THE APPLICANT'S PRE-HEARING POSITION STATEMENT ON OUTSTANDING MATTERS WITH NORTH YORKSHIRE COUNCIL

Drax Bioenergy with Carbon Capture and Storage

Document Reference Number: 8.18.1

PINS Reference: EN010120

PROJECT:	DRAX BECCS DCO				
TITLE:	FIGURE 1 LANDSCAPE AND BIODIVERSITY MITIGATION PLAN

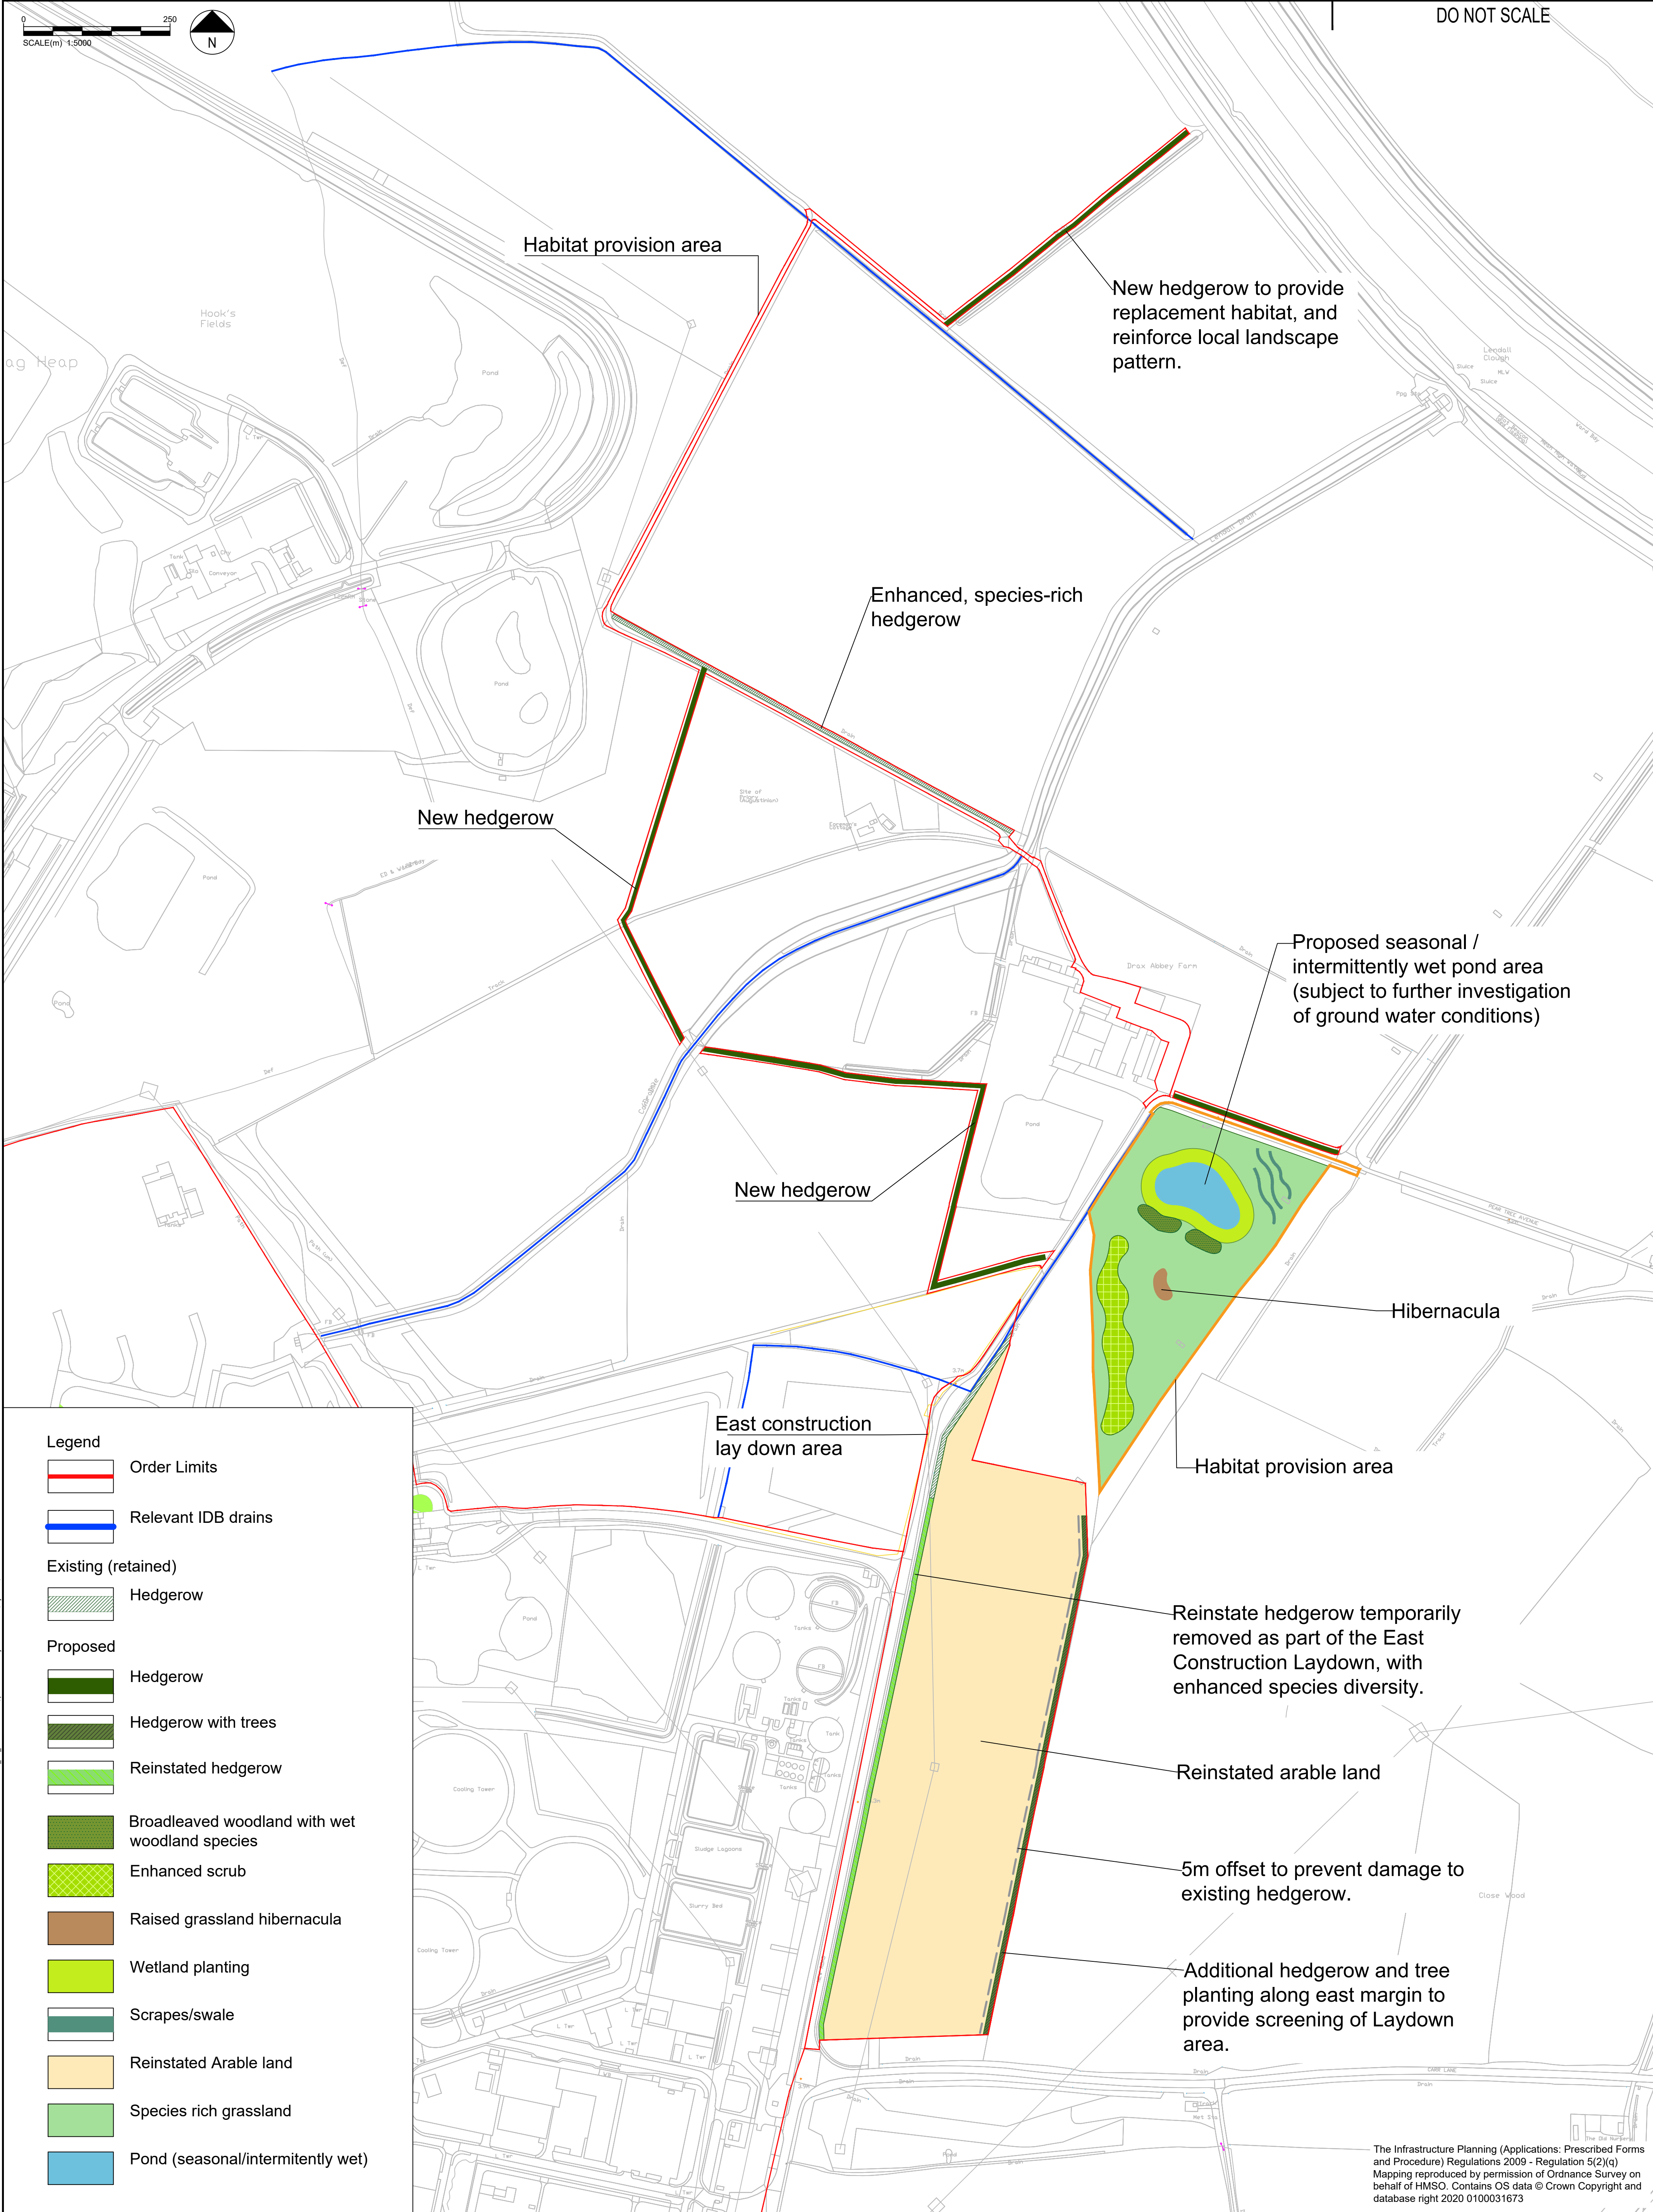
- 2.1.2. NYC consider that all existing landscape elements within the Works Areas on the Drax Power Station Site, that are unaffected by the construction and/or operation of the Proposed Scheme, should be retained and maintained for 30 years, and that this should be secured via the DCO. The Applicant does not agree that this is necessary in order to mitigate the impacts of the Proposed Scheme nor make it acceptable in planning terms; the Applicant's position is that other than where it has indicated vegetation will be retained and maintained, it cannot commit to maintaining all other existing amenity planting within the Drax Power Station Site because it may need to be removed for operational reasons in the future.

- a. *"The Council would prefer to see a commitment of no net loss of landscaping features within the OLBS. This would reassure the Council going into the detailed design stage."*

- b. *“This should not be seen [as] an overall objection to the scheme. NYC acknowledges that the power station site is an operational site but is seeking to express its concern that amenity planting could be lost because of the application rather than enhanced as it would require from development schemes. The applicant’s position on the matter is understood by the Council”.*

2.2.3. To be clear on the Applicant’s position, any amenity planting within the Works Areas will be retained wherever practicable. There may however be necessary loss of amenity planting in order to facilitate works, for example if it will obstruct construction and maintenance of the Proposed Scheme, in which case it will be removed and reinstated, the extent and detail of which will require resolution at detailed design. Where the loss of such planting is unavoidable, the detailed design will seek to reinstate those landscape elements that are temporarily lost, or to incorporate new amenity planting measures in-keeping with the original Weddle strategy aspirations for Drax Power Station (see OLBS (REP6-017) paragraph 3.3.8). What the Applicant cannot commit to is maintaining other amenity planting that may need to be removed in future connection with operational requirements of the power station site more widely.

<p>The principal issue in question</p>	<p>The brief position of the Applicant</p>	<p>What needs to:</p> <ul style="list-style-type: none"> • Change, or • Be included, or • Amended <p>So as to overcome the disagreement</p>
<p>Vegetation Retention:</p> <p>The Authority is seeking clarification that the long-term maintenance and management will extend to all existing and proposed landscape and vegetation within the Works Areas and not just new vegetation.</p>	<p>Vegetation Retention:</p> <p>The Applicant confirms their commitment to no net loss of amenity planting within the Works Areas.</p> <p>The Applicant confirms that long term (30 years) maintenance and management will be carried out for the following:</p> <ul style="list-style-type: none"> a. New amenity planting (which will be determined at detailed design stage) within the Works Areas. b. Existing landscape areas and vegetation that have been identified for retention as detailed within the Outline Landscape and Biodiversity Strategy (OLBS) (AS-094) paras 3.3.7, 3.3.8, and OLBS Figure 3 (Existing Retained Vegetation) (APP-183). c. Removed and reinstated amenity planting within the Works Areas. <p>Other than as indicated above, the Applicant cannot commit to maintaining all existing amenity planting within the Works Areas on the Drax Power Station Site, however the Applicant confirms that it would only seek to remove vegetation for operational reasons.</p>	<p>In order to resolve the issue of the long term maintenance and management of all existing vegetation within the work areas:</p> <ul style="list-style-type: none"> a. NYC should provide the justification for this requirement within the context of the DCO Application, the tests for DCO requirements, the mitigation requirements, and the proposed commitments relating to landscape. b. The Applicant can confirm that NYC will be included in the detailed design process relating to landscape, which will include involvement on the landscape design proposals, landscape specifications and landscape management plans, as a consultee, a reviewer, and an approver. This is secured via the DCO - Schedule 2, Requirements: <ul style="list-style-type: none"> i. R6, Detailed design approval. (1) In relation to any part of the
